Application No: BR/56/21/PD
Site Address: 252 Hawthorn Road Bognor Regis PO21 2UP
Description of works: Prior notification under Schedule 2, Part 1 Class AA for an additional storey on existing dwelling.

Thank you for your internet representation made on 30th March 2021 which has been recorded as no objection with the comments as follows:

Drawing Title:
PROPOSED ELEVATIONS

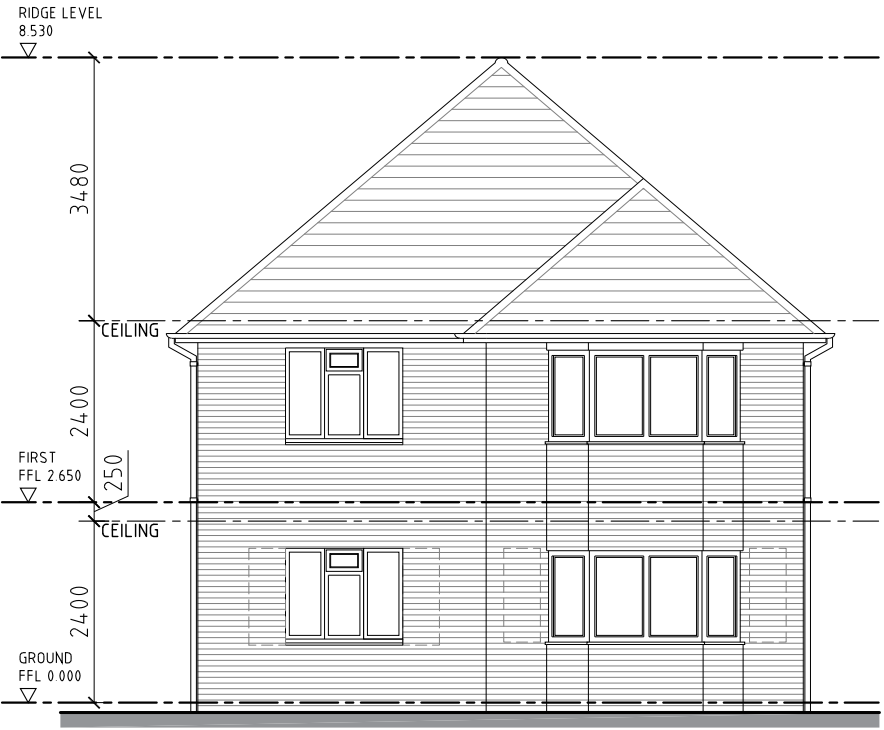
I do have a concern over the potential loss of light that we may suffer due to the increased height of the adjacent modified building which I would look to you for re-assurance on this point. We are grateful that there will be no windows fitted on the first floor north east facing side, i.e. next to our property, as this would have meant that our property would have been directly overlooked and we would have lost privacy both inside and outside of our home. There does appear to have been a good deal of consideration shown to our property in the proposed re-design for which we are grateful.
